Date: February 8th, 2023
Subject: Correction Notice #2
Project: 6221 83rd PI SE, Mercer Island
MI project # 2207-110

The following are issues and responses raised in the second Building Permit correction round:

**BUILDING SECTION**

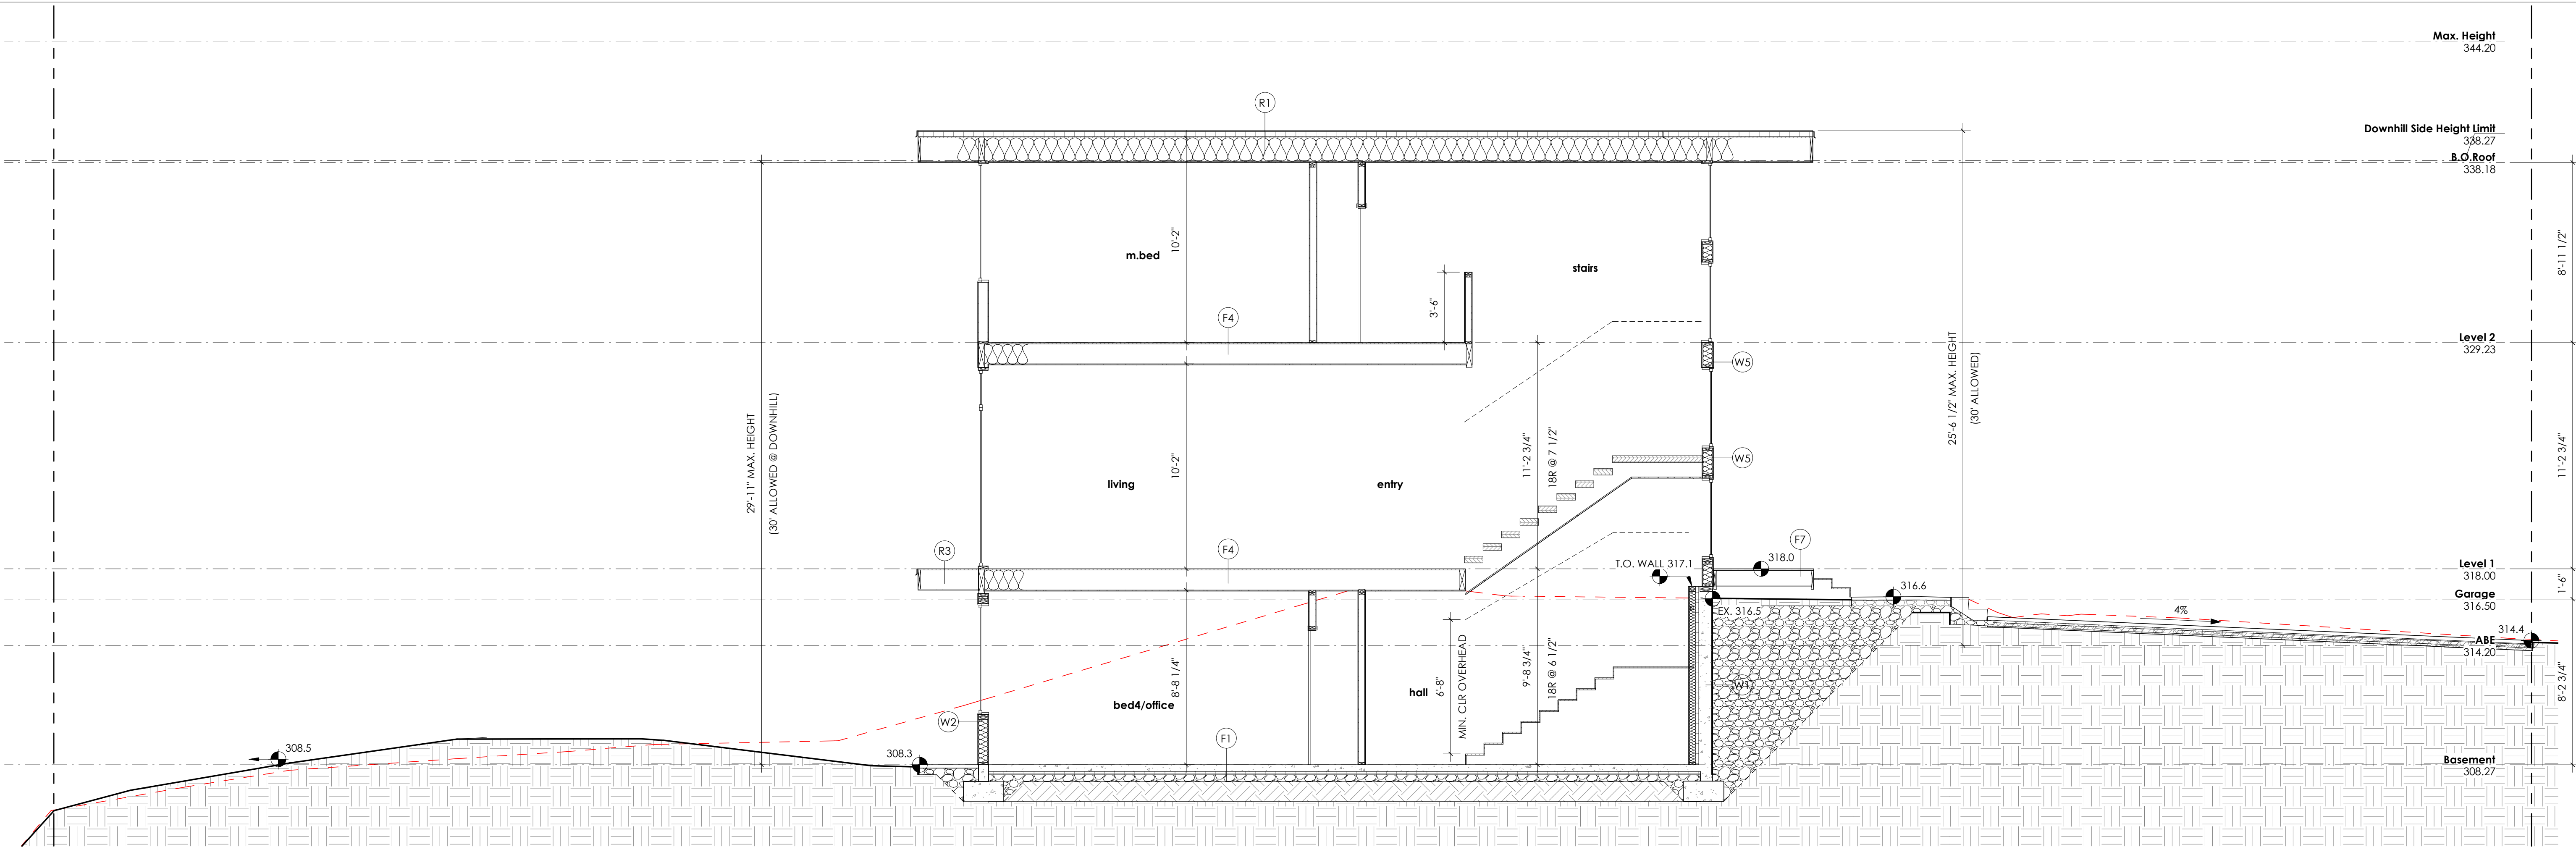
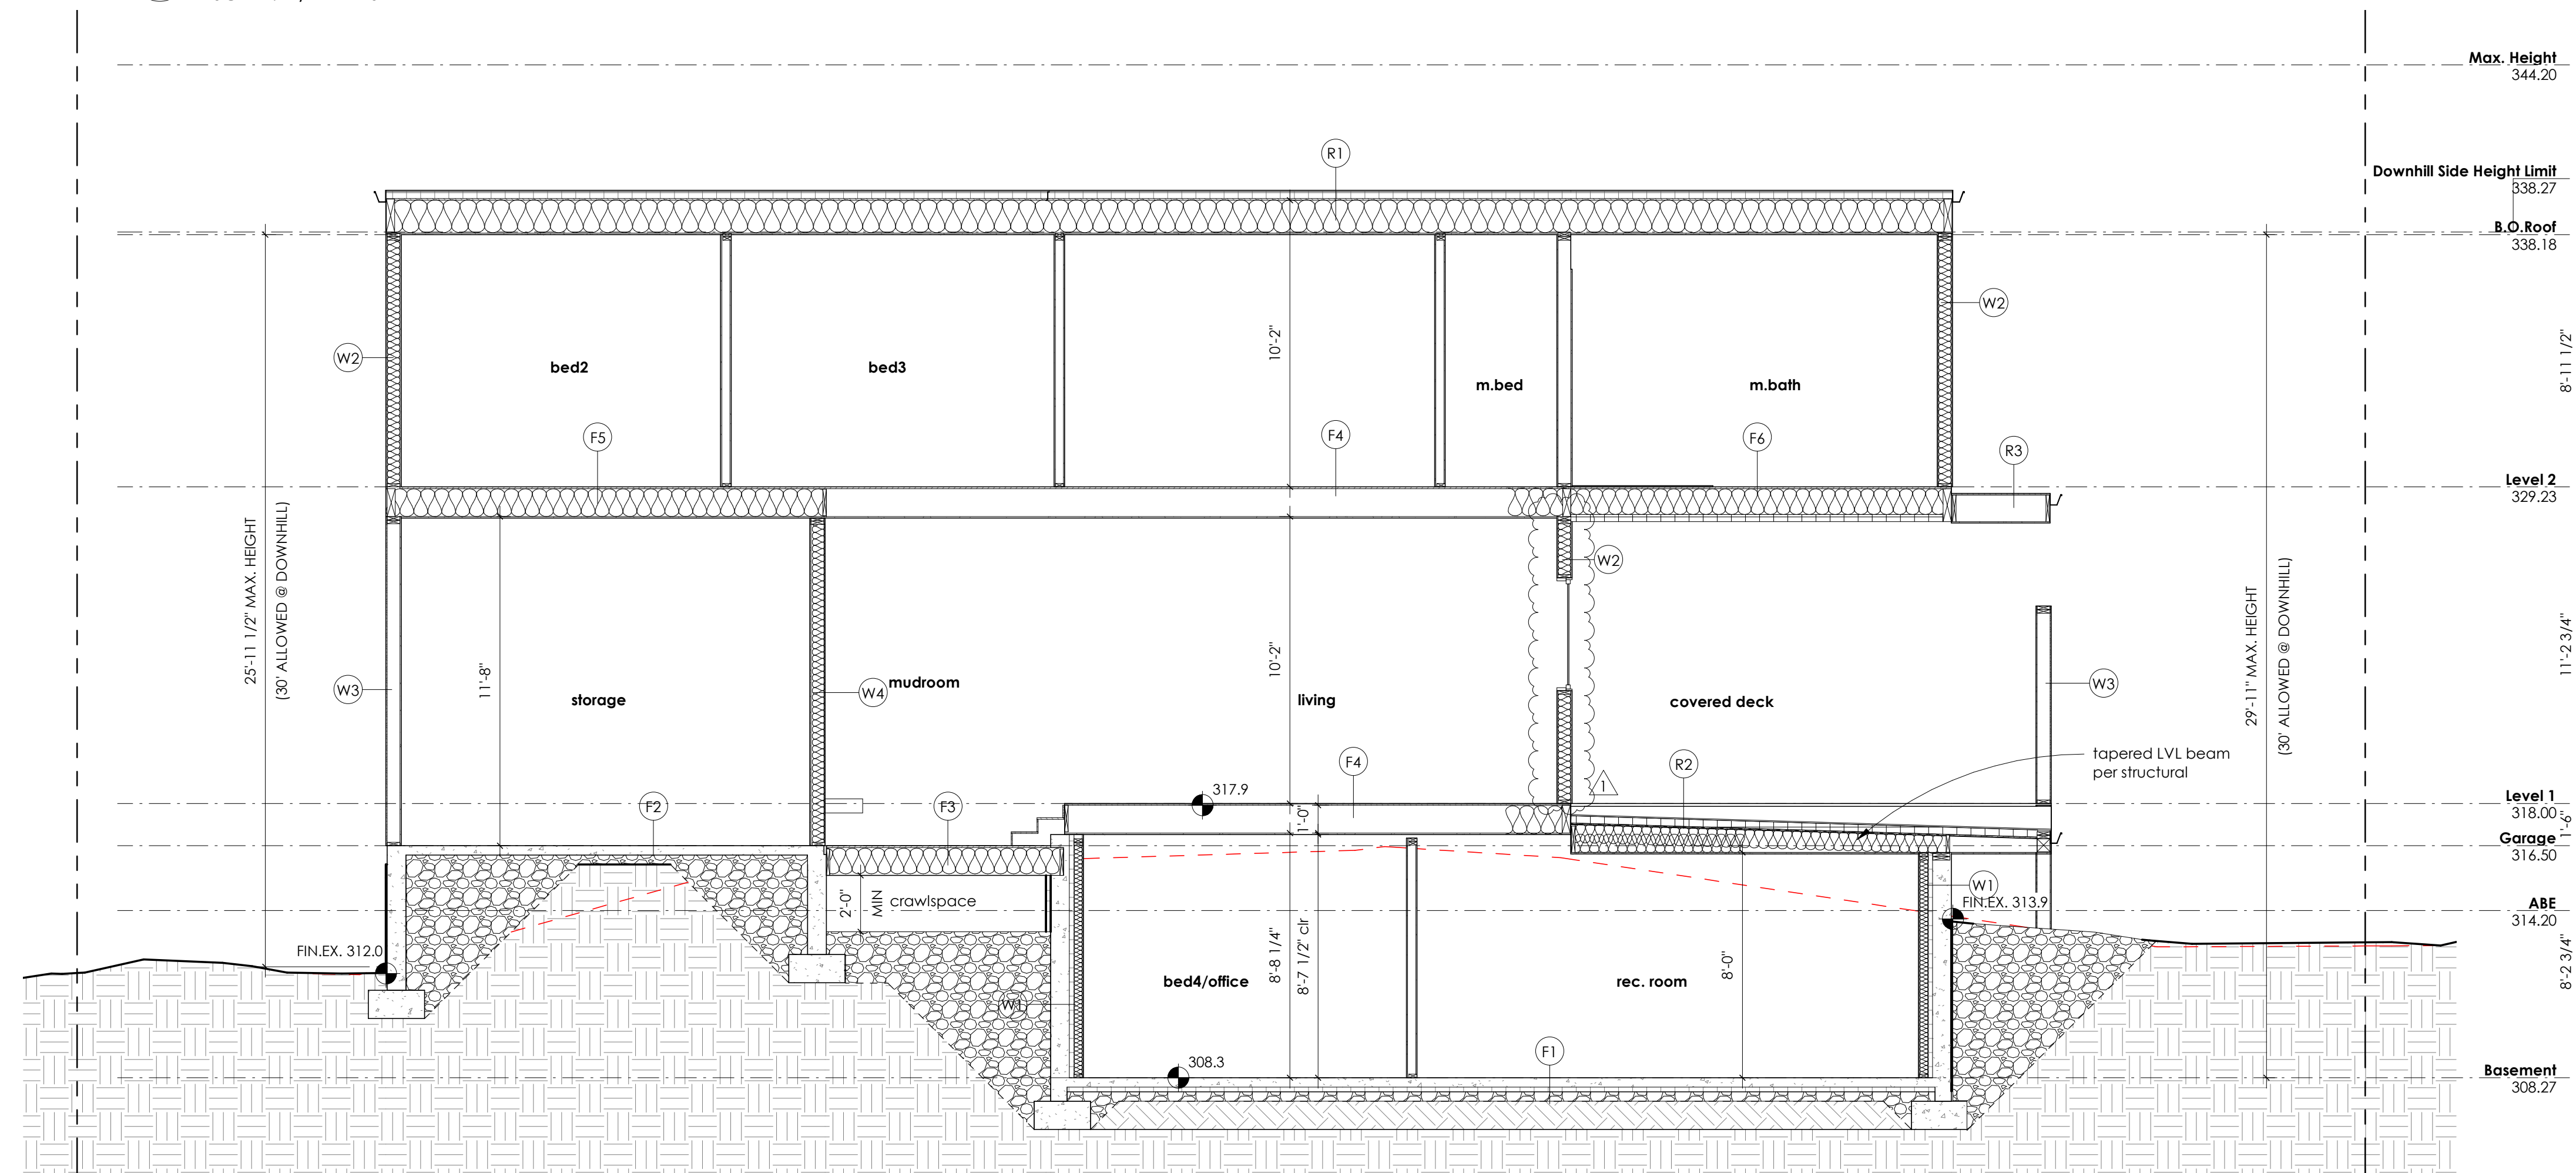
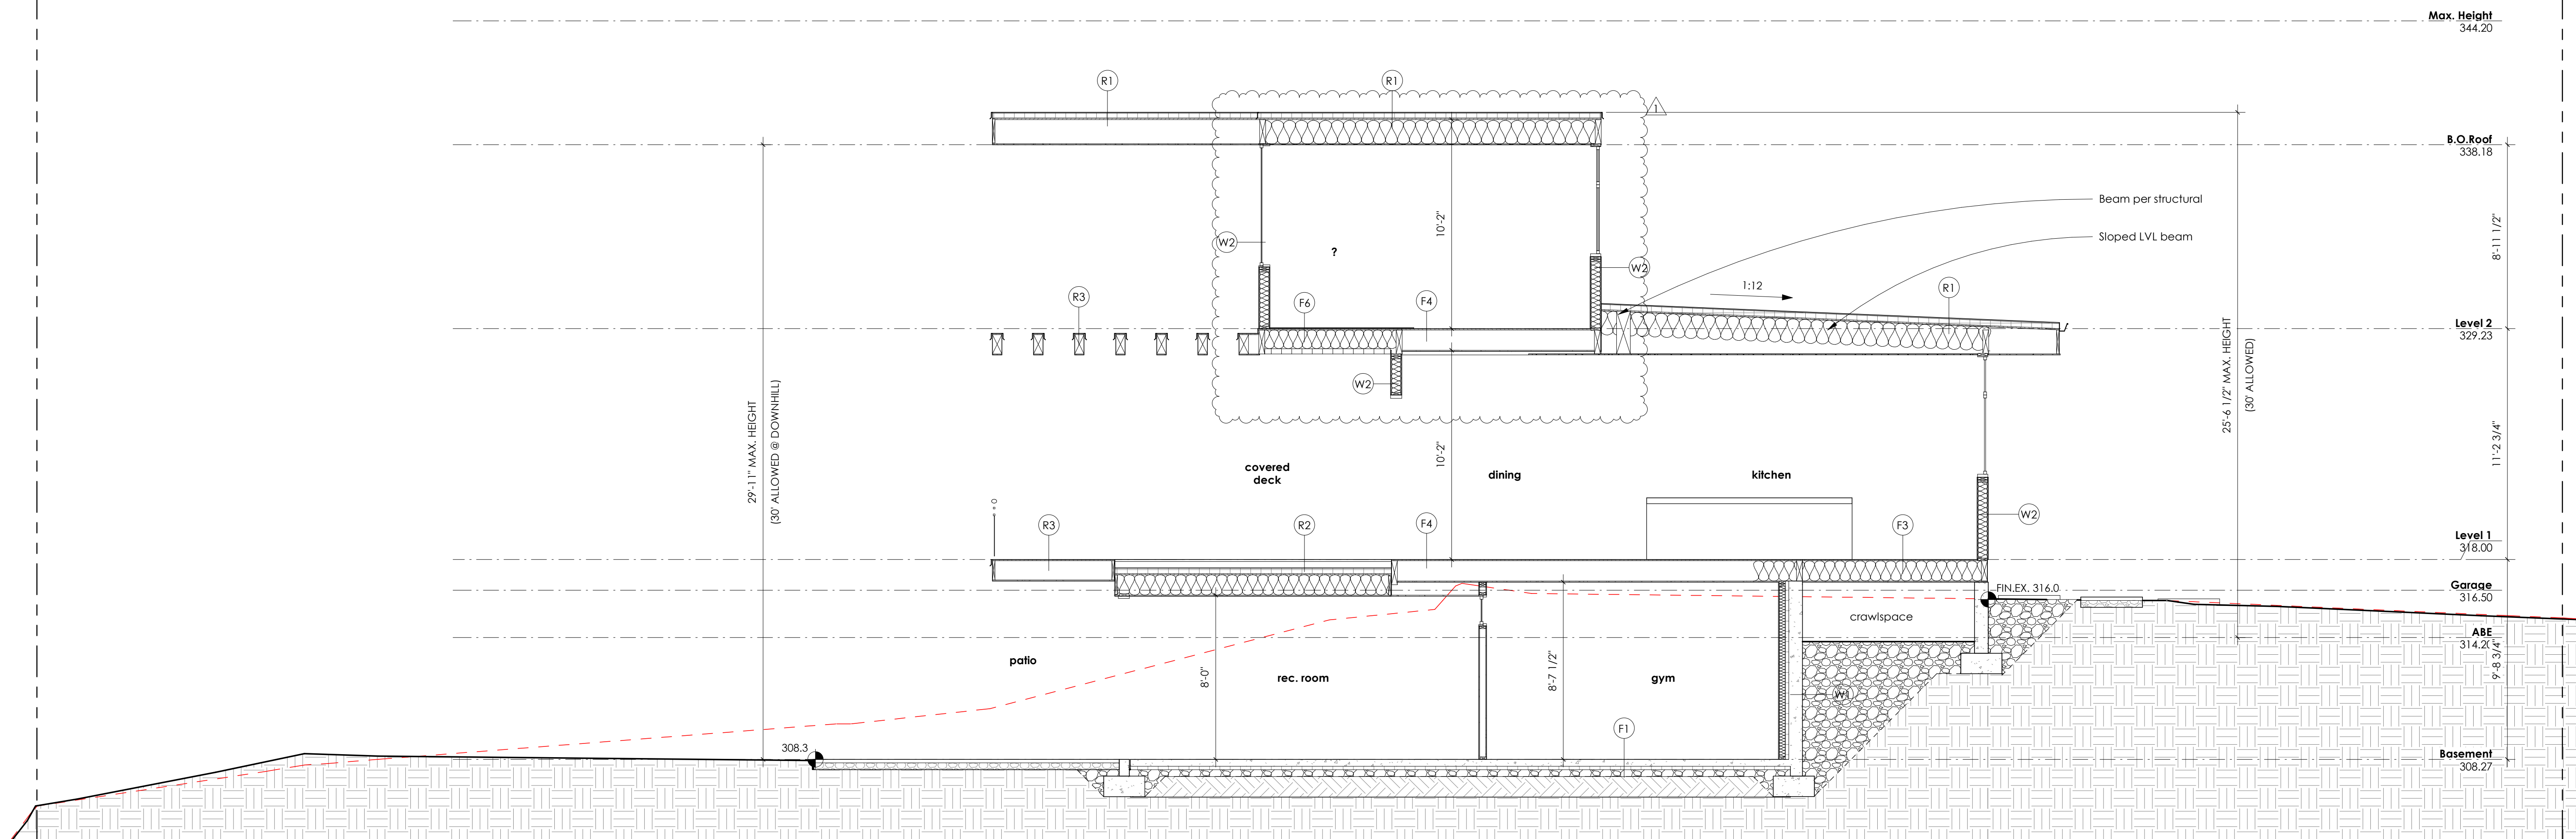
Sub2 Comment: Please note the manufacturer and model of the product, and confirm that the installation manual includes details for this application. If installation is not in conformance with a manufacturers' detail, provide a statement from the installer describing the installation procedure and warranty referencing the roof deck detail.

- a. Please see further product information noted on the roof assemblies on sheet, A4.1. Please see the statement uploaded from the installer describing the installation procedure and warranty referencing the roof deck detail. Thank you for your coordination.
